Please ask for: Nicola Moore
Email: nicola.moore@arun.gov.uk
Telephone: Ext 37944
Our Ref: BR/122/20/OUT
Your Ref:
Date: 20th July 2020

Application for Outline Planning Permission

Development: demolition of garth house and west view to be replaced with 20 self contained apartments
Location: Garth House High Street Bognor Regis PO21 1HQ

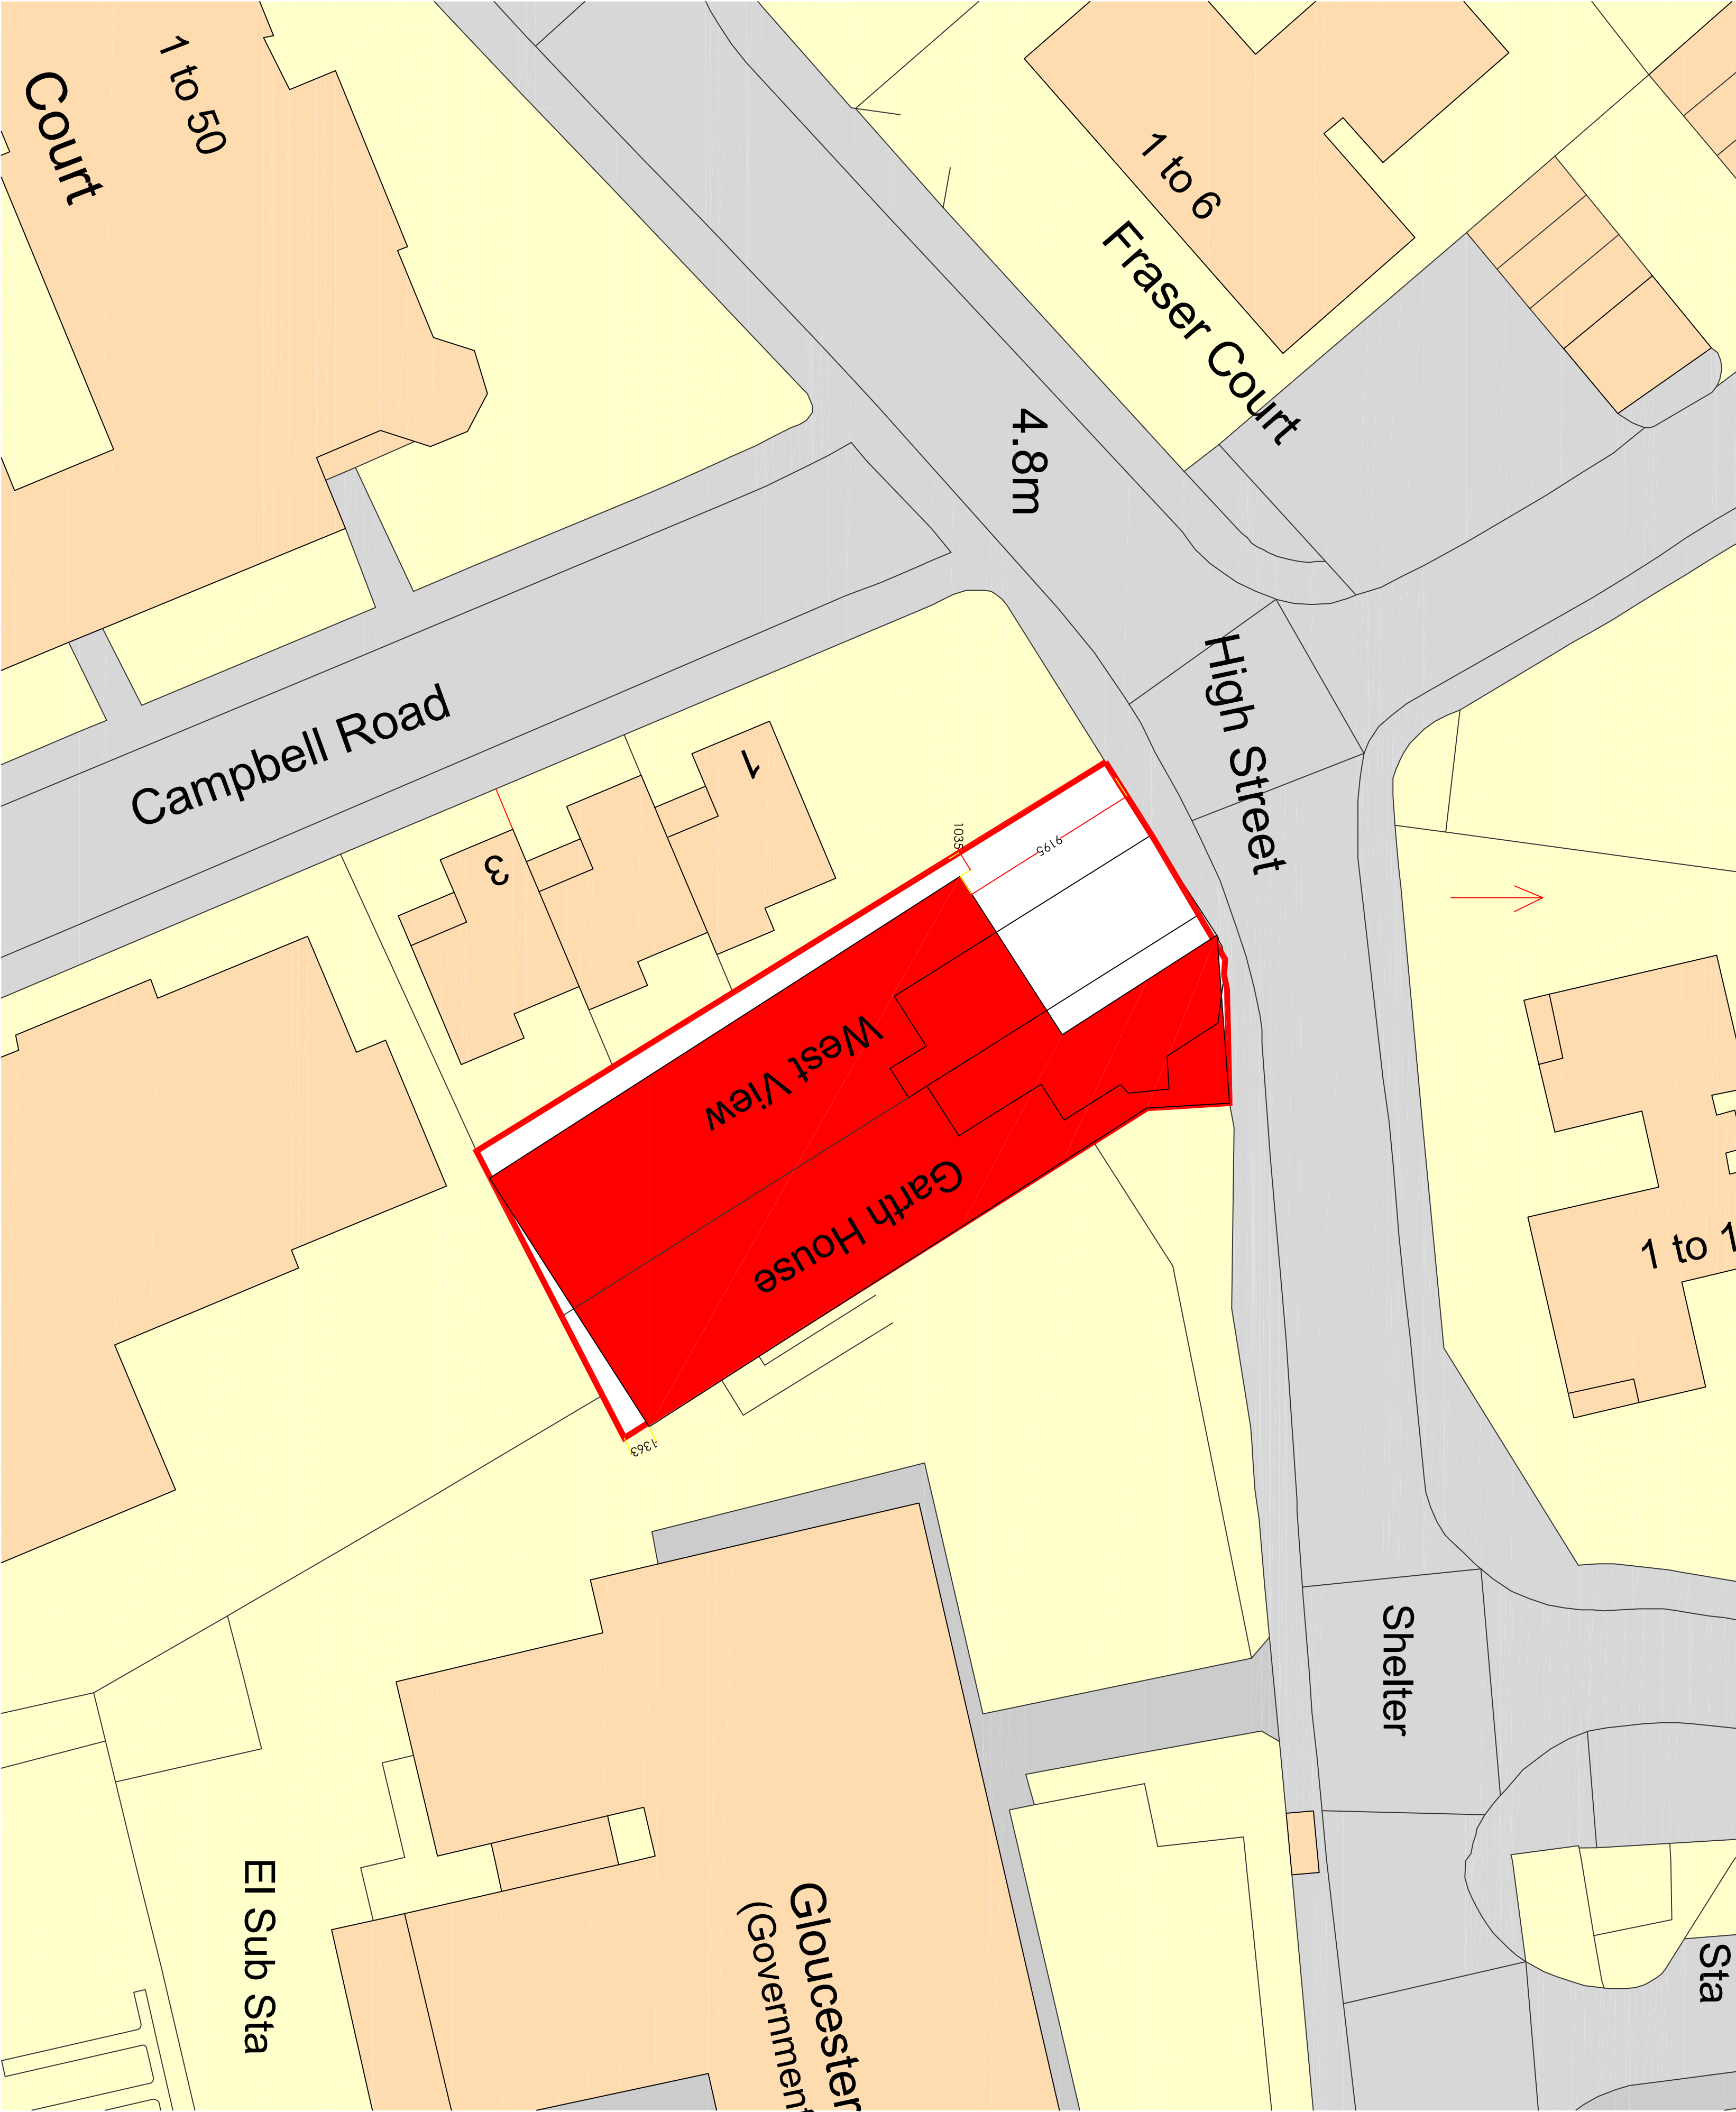
Please amend the Block Plan to show the direction of North and remove red edges that are not applicable to the application site. The Block plan should also include the footprint of the demolished building/s and all measurements to boundaries of the proposed development. Please submit at a scale of 1:500 or 1:200
